Your ref: SSD-78156221
Our ref: DOC26/154809

Subject: Request for Advice on Submissions and Amendment Report – Mixed-use development with in-fill affordable housing - Cecil Avenue and Roger Avenue, Castle Hill (SSD-78156221)

CPHR response on the Submissions and Amendment Report – Mixed-use development with in-fill affordable housing - Cecil Avenue and Roger Avenue, Castle Hill (SSD-78156221)

93-107 CECIL AVE & 9-10 ROGER AVE, CASTLE HILL			
DRIVEWAY - CECIL AVENUE - SHEET 1			
Size	Status	Dwg No.	Rev.
A3	FOR SSD APPLICATION	CV-100	1

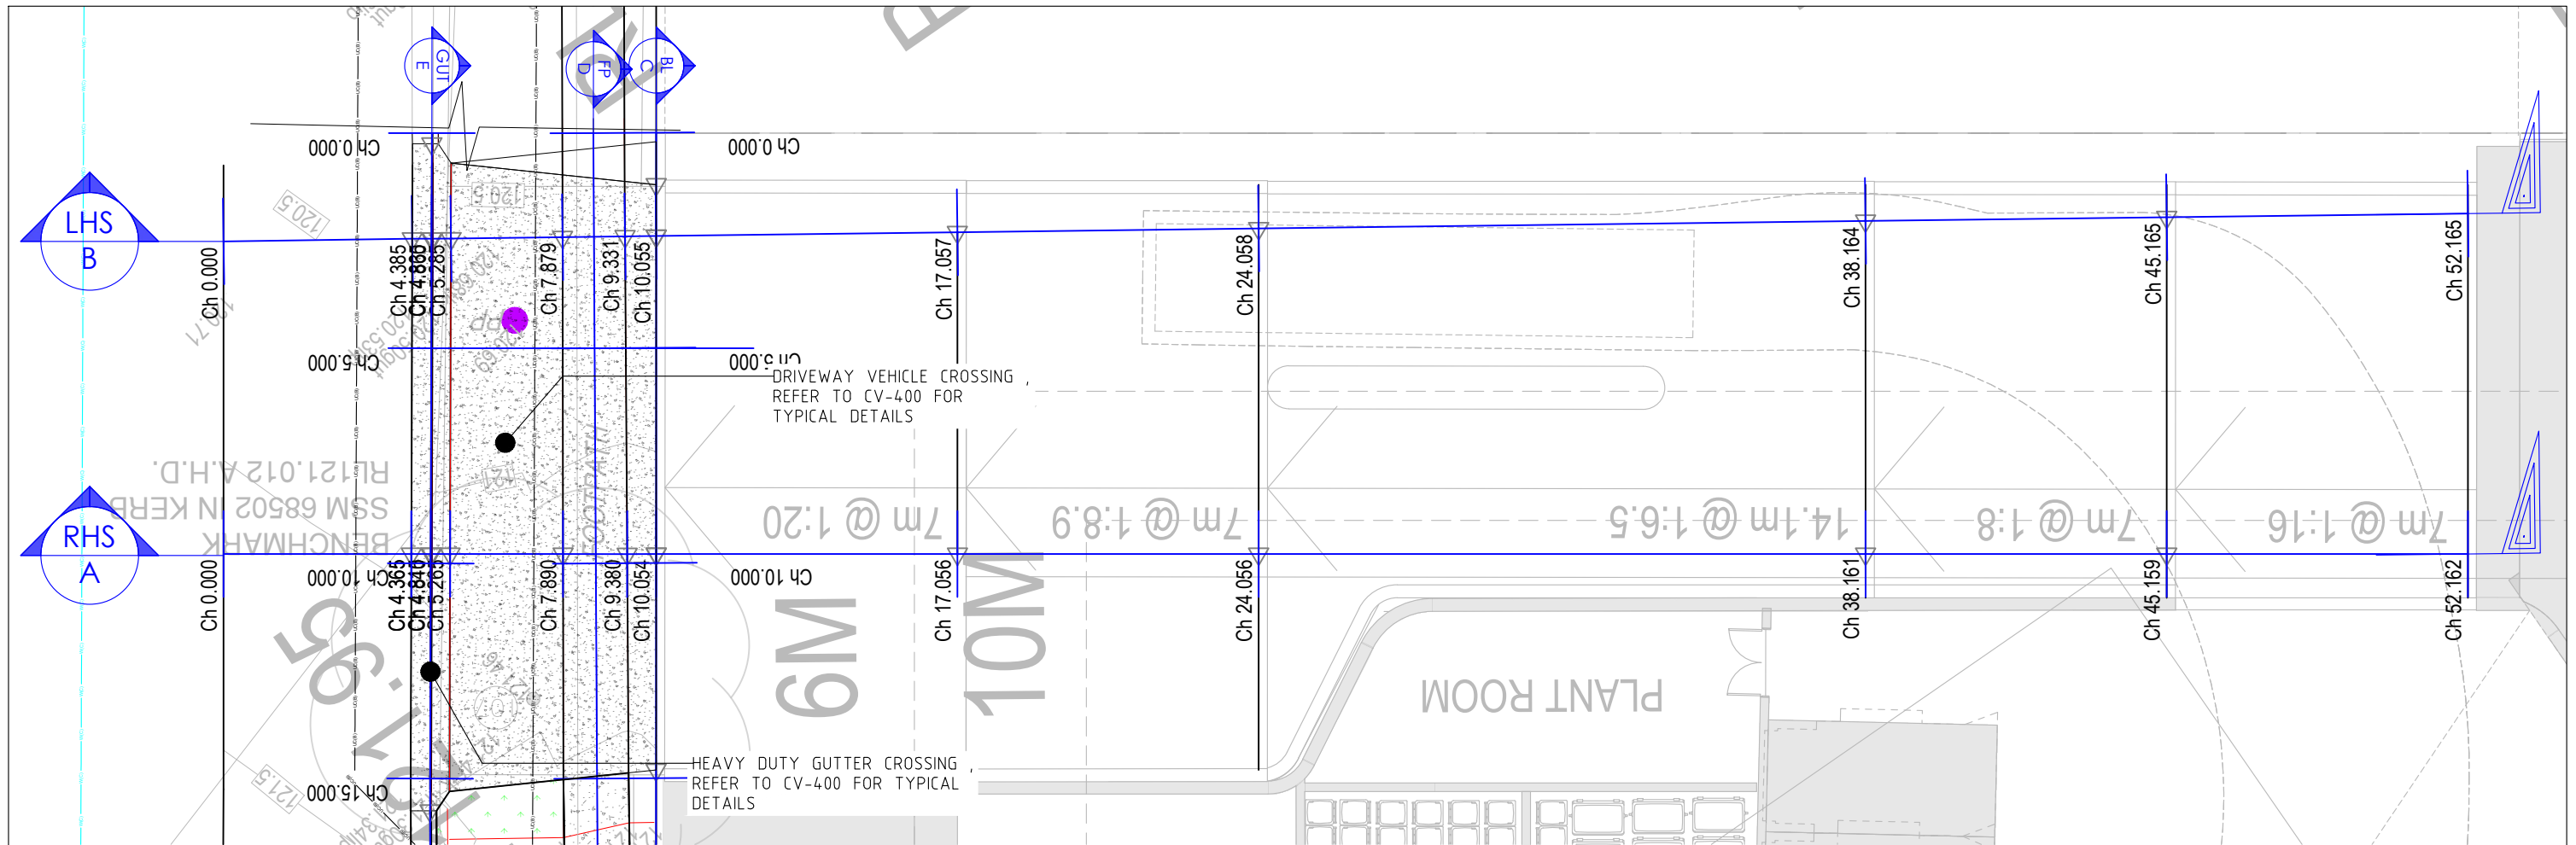
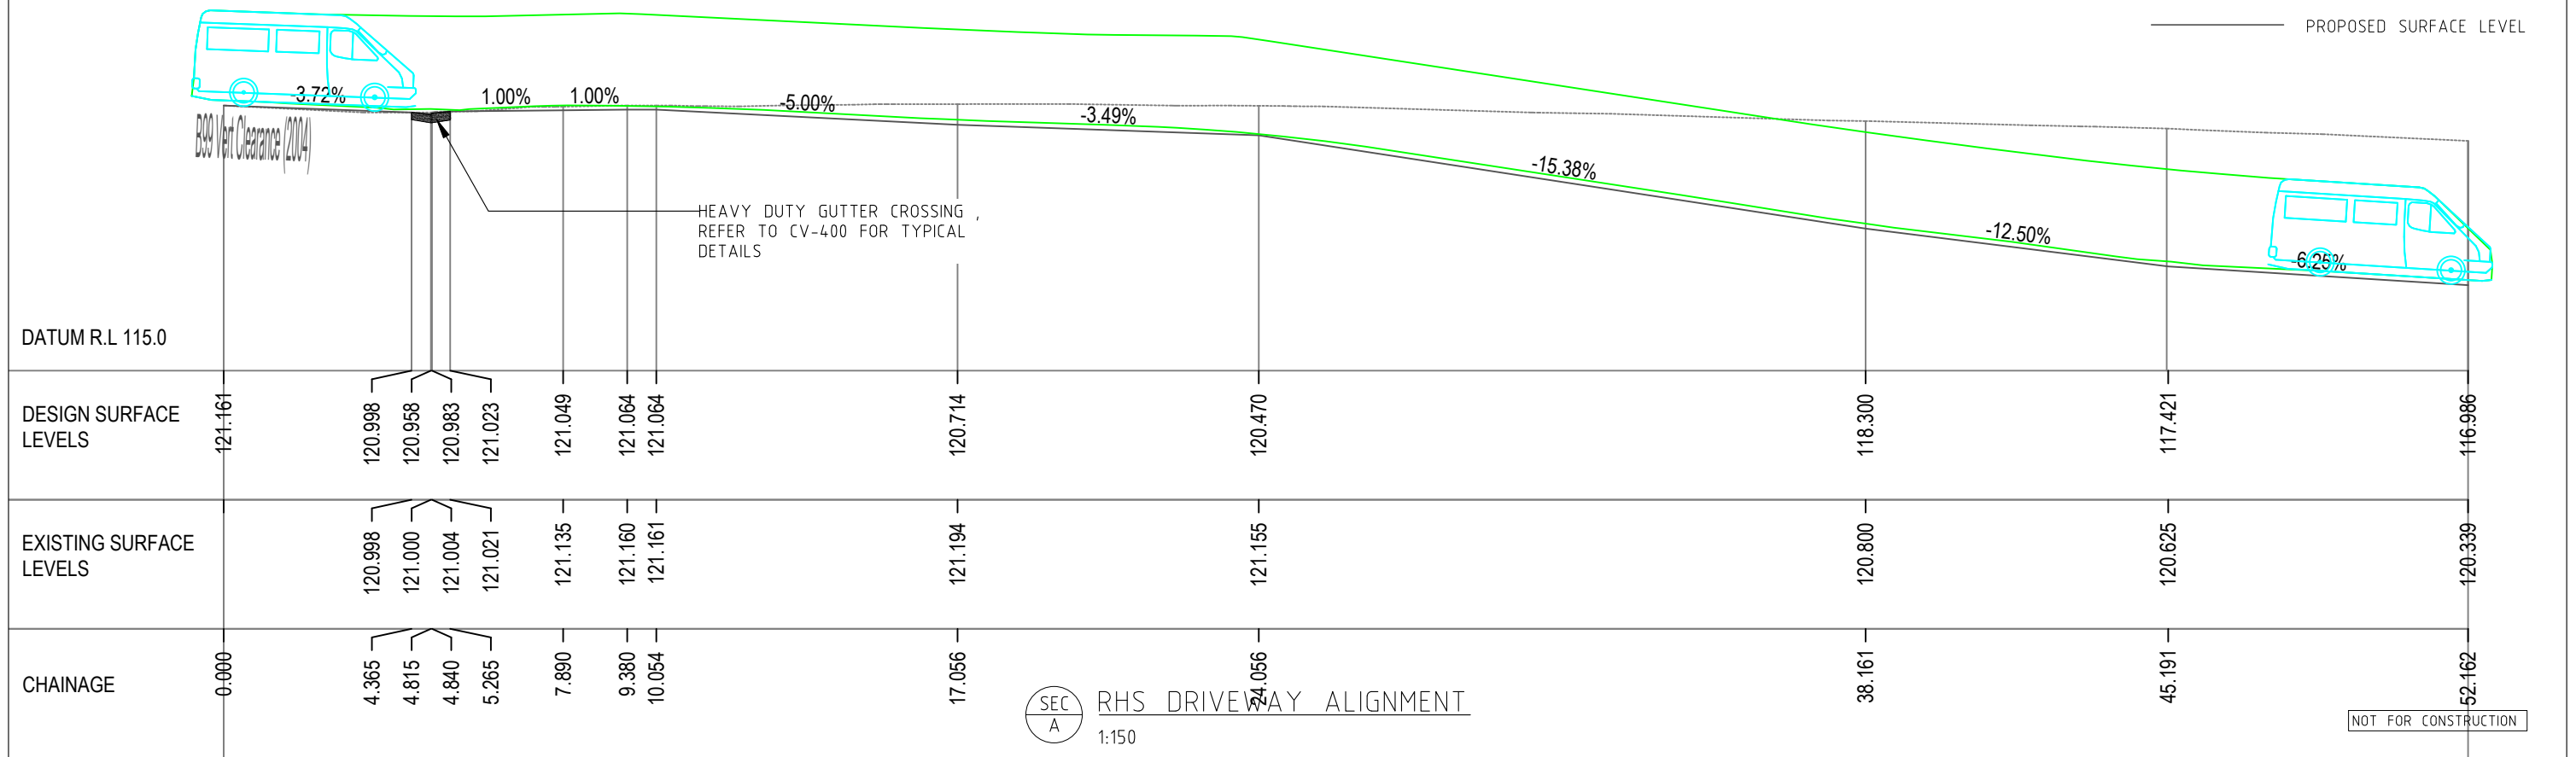
identified. The original easement location/overland flow path has not been provided. • It is unclear what the levels of overland flow are at the basement car park access. It is noted that only a 1% crossfall to the crest level is included. This may not offer any protection to the basement from overland flows during more extreme storm events. • The probably maximum flood (PMF) has not been assessed and the impact on the development is not clear. • The Assessment has assumed flows from a sub-catchment at the intersection of Cecil Avenue and Terminus Street continue north along Terminus Street rather than flowing towards the development. The catchment topography suggests flows would continue down Cecil Avenue. This should be amended. Recommended action: • Provide a Flood Impact and Risk Assessment (FIRA) consistent with the NSW Government's Flood Risk Management Guideline LU01. The FIRA must identify flow paths affecting the site, required basement carpark crest levels and any impacts on neighbouring properties due to redirection of flows.
